Condition Compliance Document

Swauk Valley Conservation Plat File Number LP-17-00007 Compliance Document

Date: 3-28-18
Scale: 1"=200'
Drawn By: JG
Surveyed By: JG/TB
Checked By: JG
Sheet 1 Of 3
Job Number: 2016-SWK

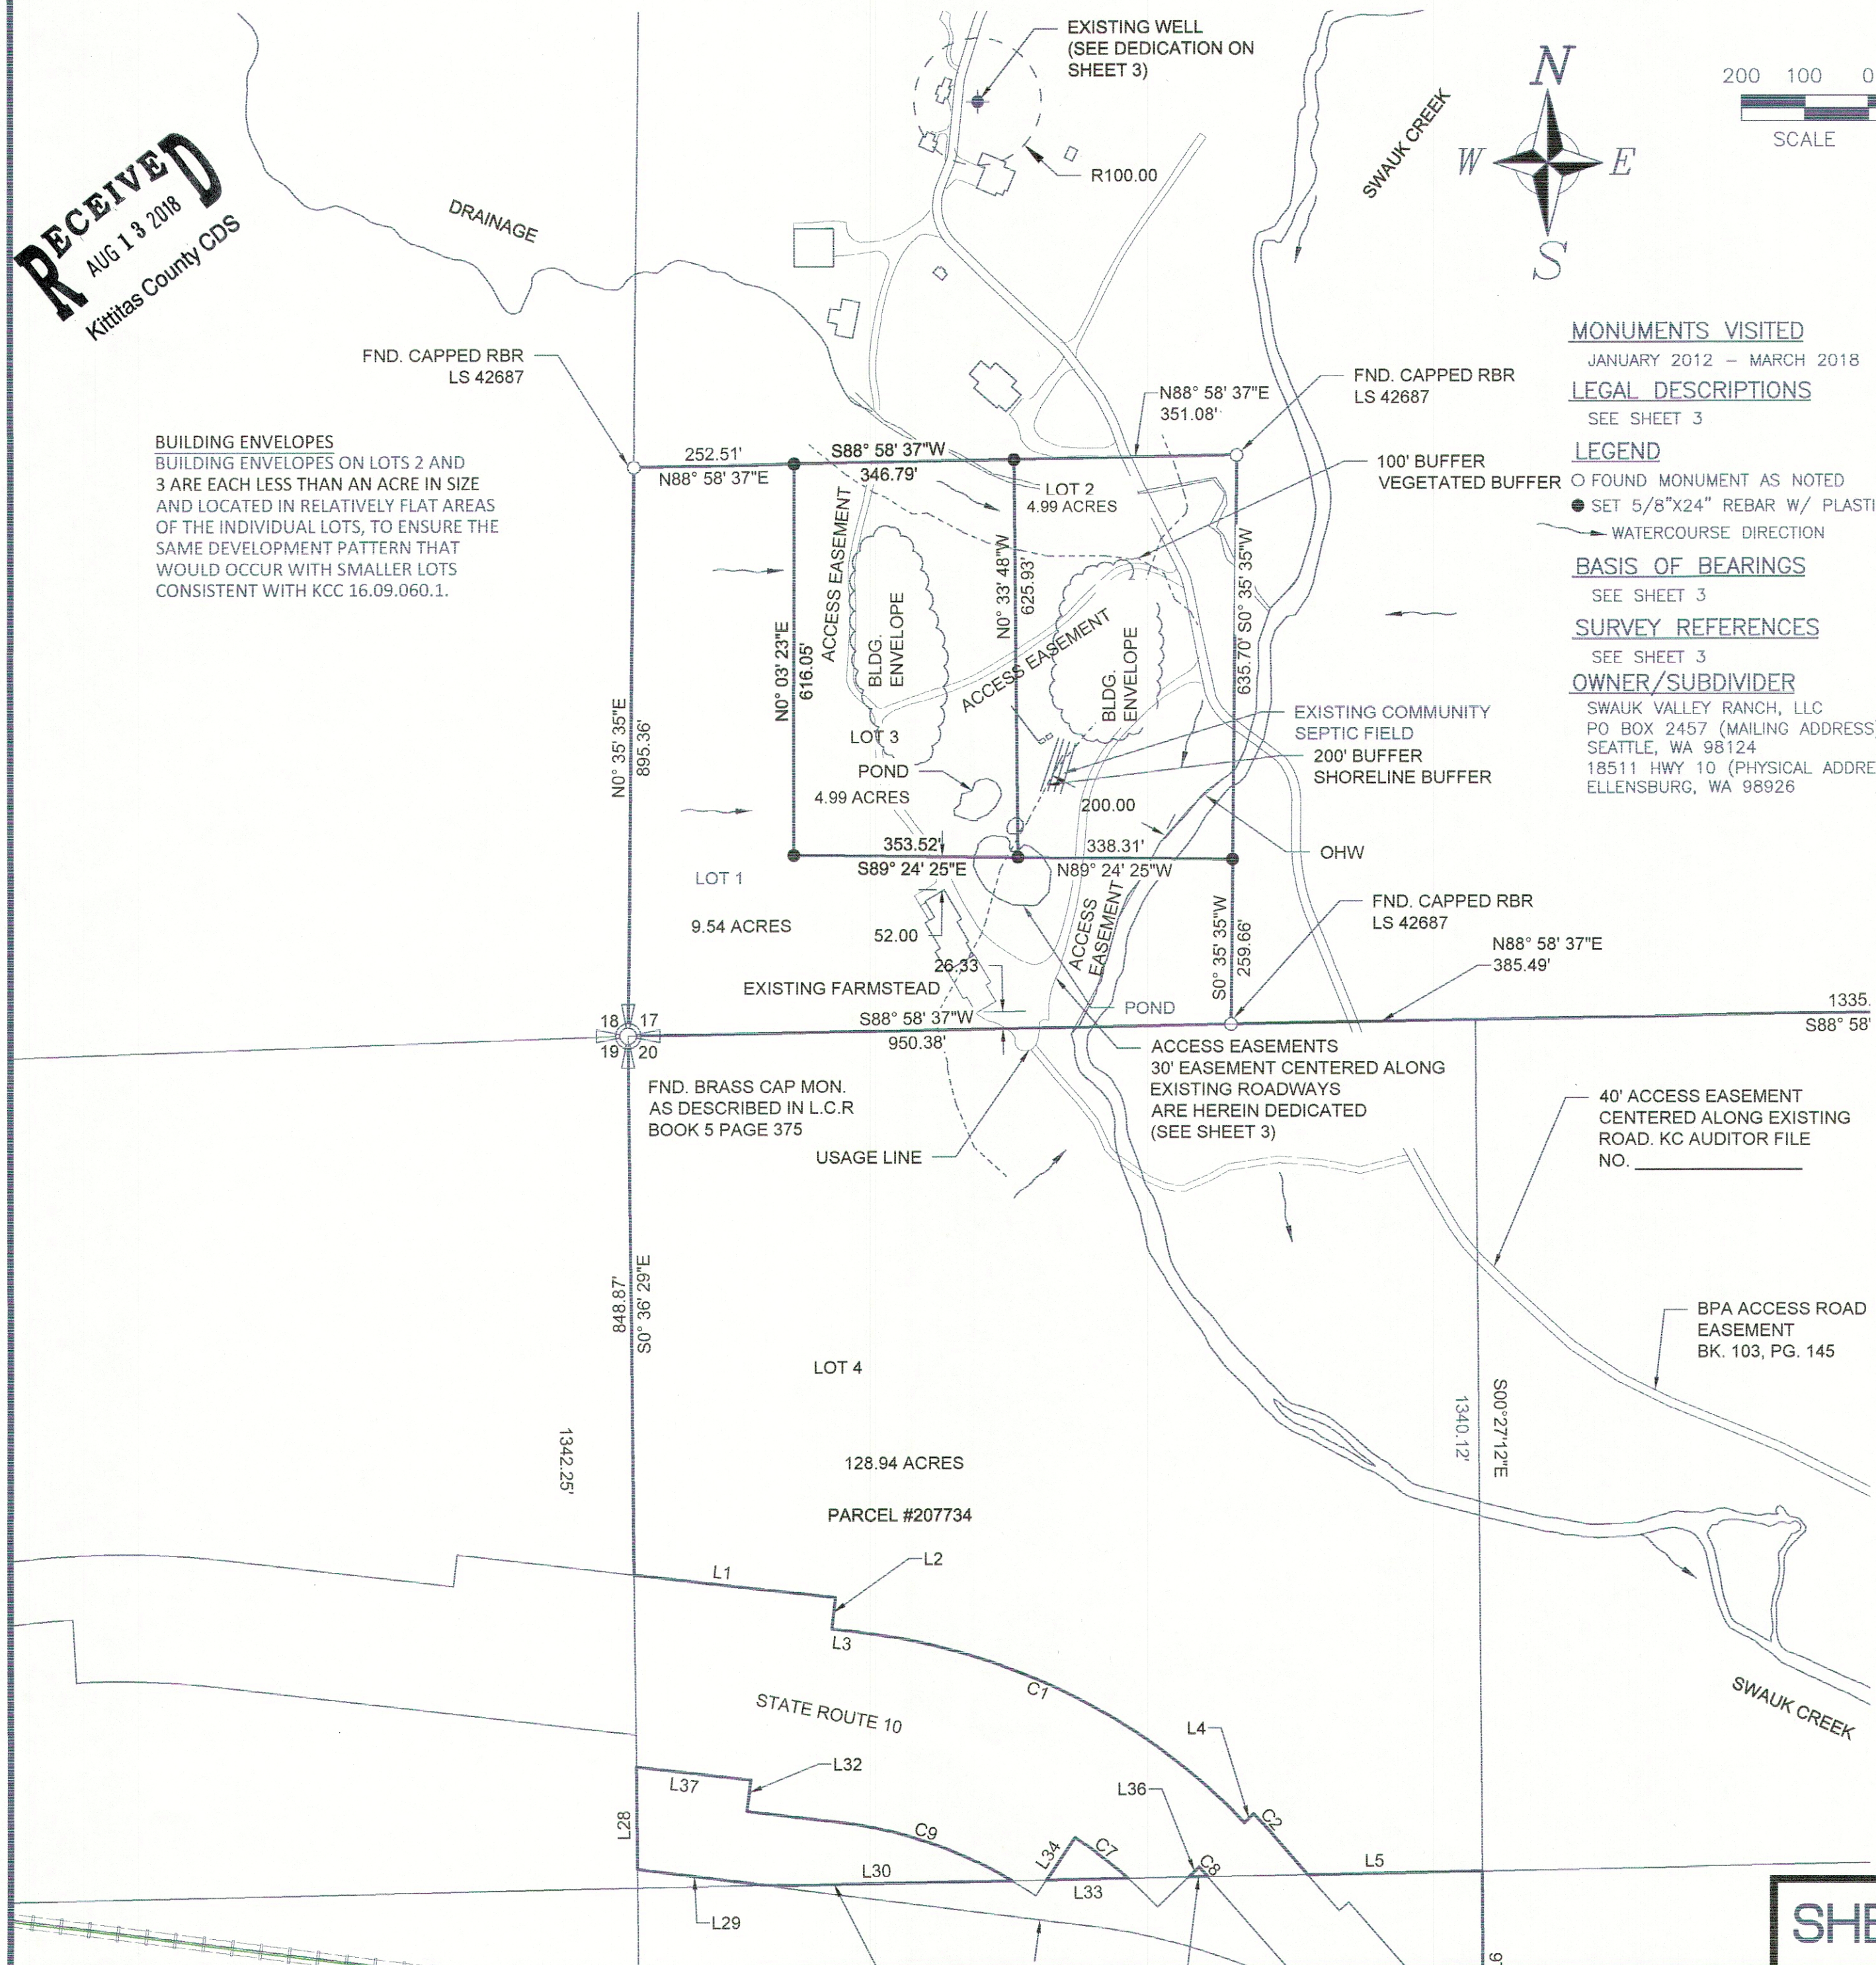
25. The applicant will place the open space tract of 130.72 acres in Open Space for perpetuity and will be designated on the final Mylar

26. The use of the open space area will be for passive and active recreational uses as allowed in KCC 16.09.

Placement of Lot 4 (Open Space Tract) noted on Sheet 1 of drawings.

Noted on Sheet 1 of drawings.
